November 14, 2025

**Re: Taco Bell – 98th & Sage at 1115 Snow Vista Blvd SW
Erosion and Sediment Control Plan – M09E012D – (SWQ-2025-00056)
Engineer’s Stamp Date: 6/3/25**

Based on the information in your submittal received on 11/11/25, the ESC Plan and Notice of Intent (NOI) cannot be approved until the following comments are addressed.

DEMOLITION AND  
INITIAL EROSION  
CONTROL PLAN

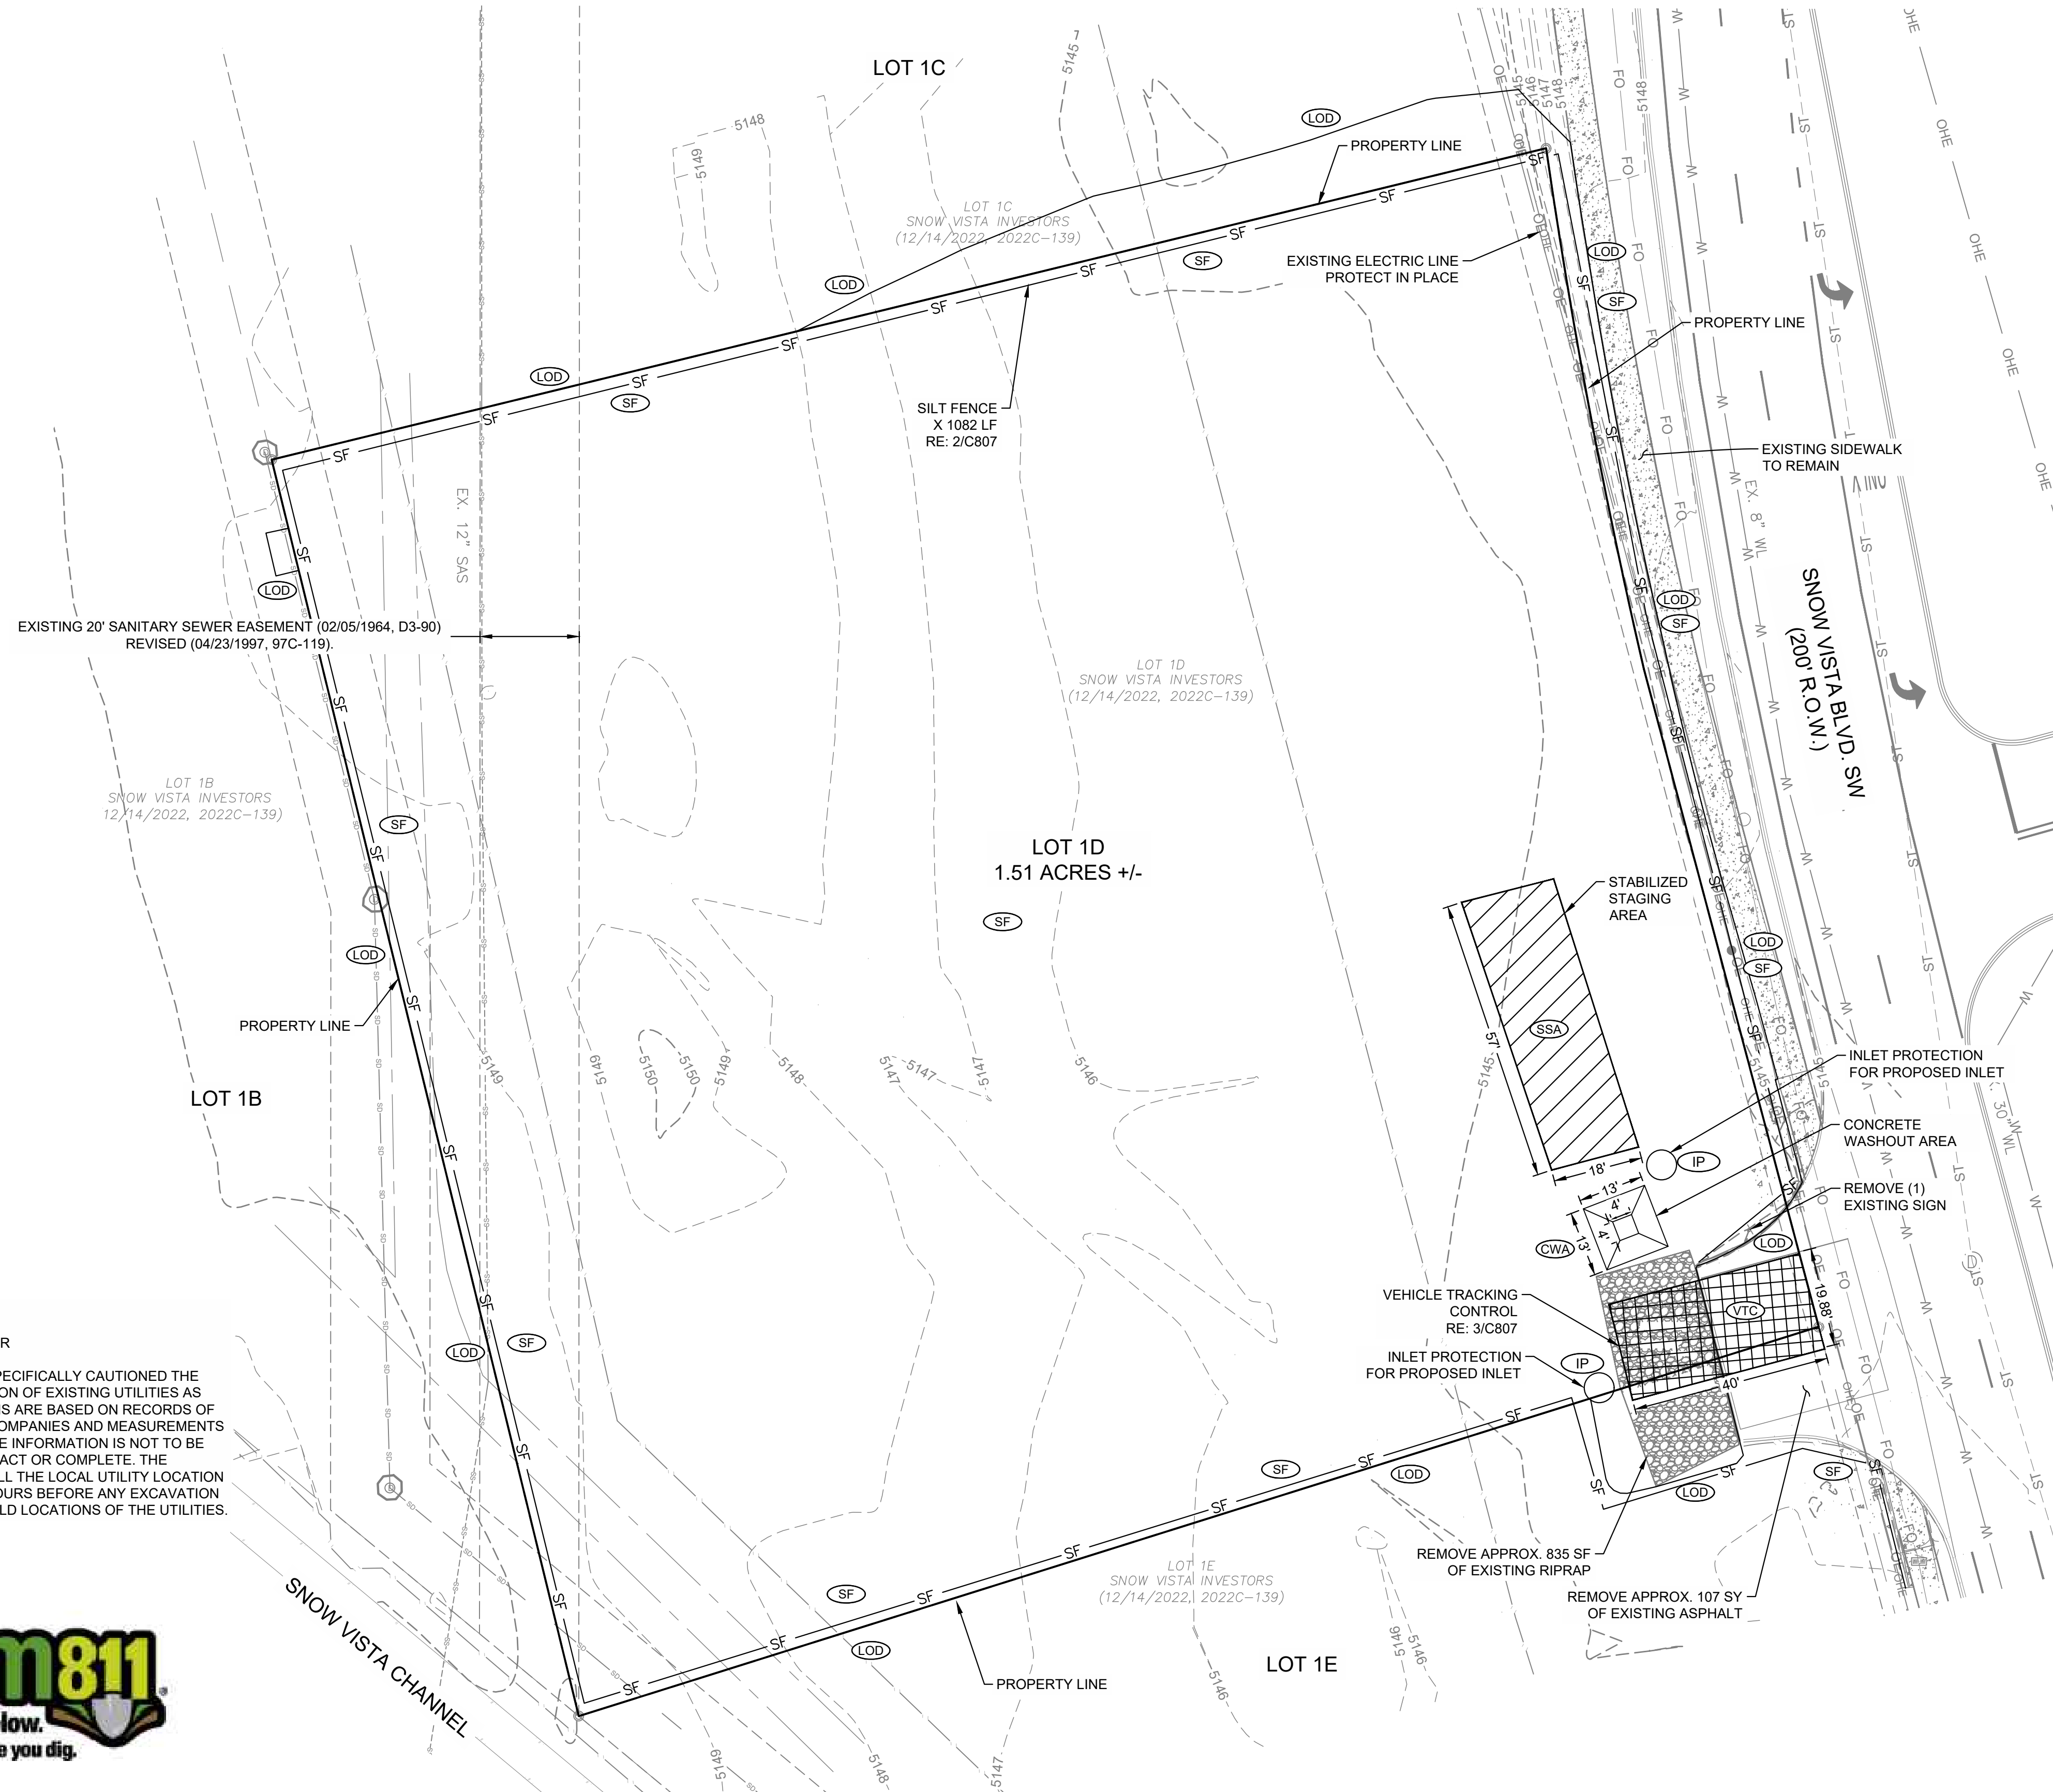
1. The ESC Plan can't be approved until after Hydrology approves the G&D Plan for each specific purpose, Site Plan, Grading, and Building Permit. The only purpose Hydrology has approved so far is DFT action on the Site Plan. The existing and proposed grades must be shown on the ESC Plan and agree with the Grading Plan approved by Hydrology per CGP 7.2.4.b.ii.

2. The proposed contours are shown on the adjacent property to the south outside of the limits of disturbance. The limits of disturbance must include all off-site grading, and off-site areas must be stabilized with rock per CGP 2.2.14.C.ii. Include stabilization construction specifications on the ESC Plan for the off-site disturbed areas.

5. Identify locations of concentrated flow paths that enter and exit the disturbed area. Show on-site drainage patterns of stormwater before and after major grading activities per CGP 7.2.4.f. including existing and proposed storm drains.

6. Silt fence is not an effective stormwater control because most of this site drains at concentrated discharge points or sheet flow across the south boundary, which isn't level. Silt fence must be constructed on contour to control sheet flow only, never concentrated flow. Therefore, sediment traps must be sized to retain stormwater onsite during construction and must be the first items of construction. Provide design calculations per CGP 2.2.12 and construction specifications in accordance with good engineering practices as required by CGP 9.6.1.c.i. Add construction notes to ensure the required volume doesn't drain through the storm sewer pipes until construction and stabilization are complete.

DATE 06/03/2025  
PROJECT NO. 2175023  
SHEET NAME  
FINAL EROSION CONTROL PLAN  
SHEET NO.  
**C301**

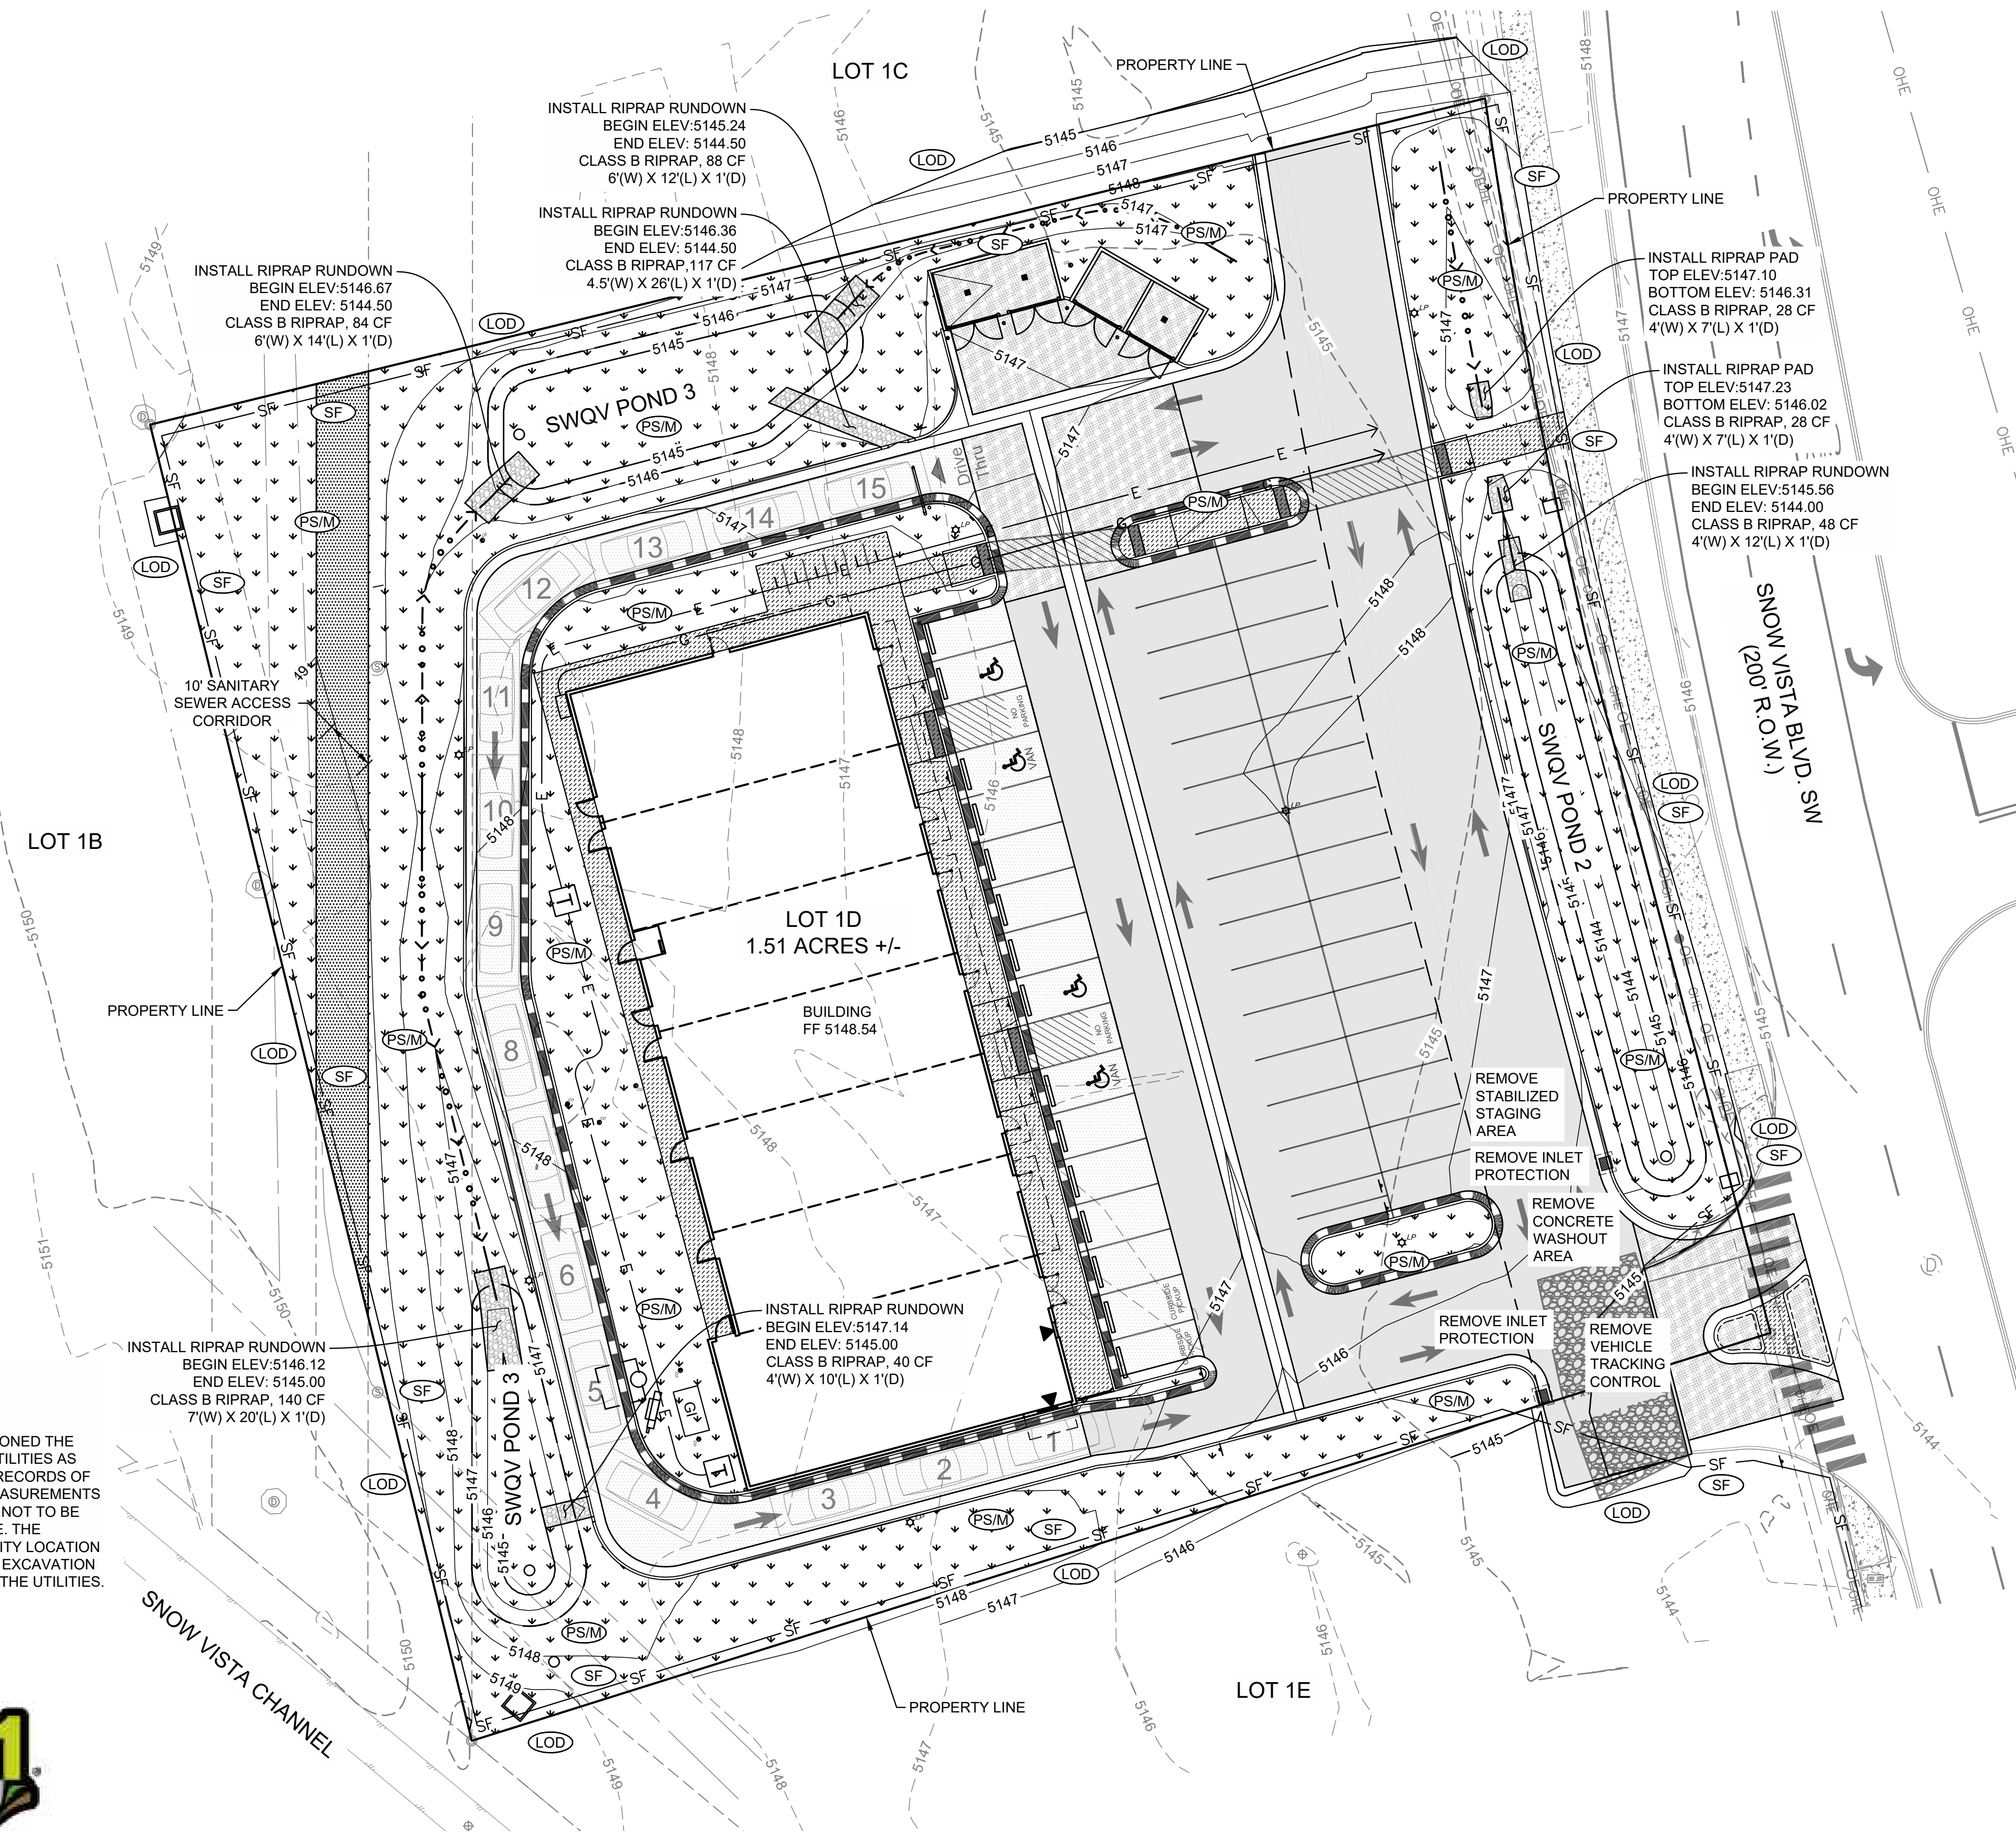
3. The SWPPP must include site-specific interim and permanent stabilization per CGP 9.6.1.c.i. The Landscape Plan can be used to satisfy this requirement and should be submitted separate from the ESC Plan with the SWQ resubmittal in ABQ_PLAN and included in the SWPPP. Provide a specification on the ESC Plan for any disturbed areas not covered by the Landscape Plan and specify a "Landscape Buffer Swale" between the sidewalk and curb, per "COA DWG 2414," along Snow Vista Blvd frontage.
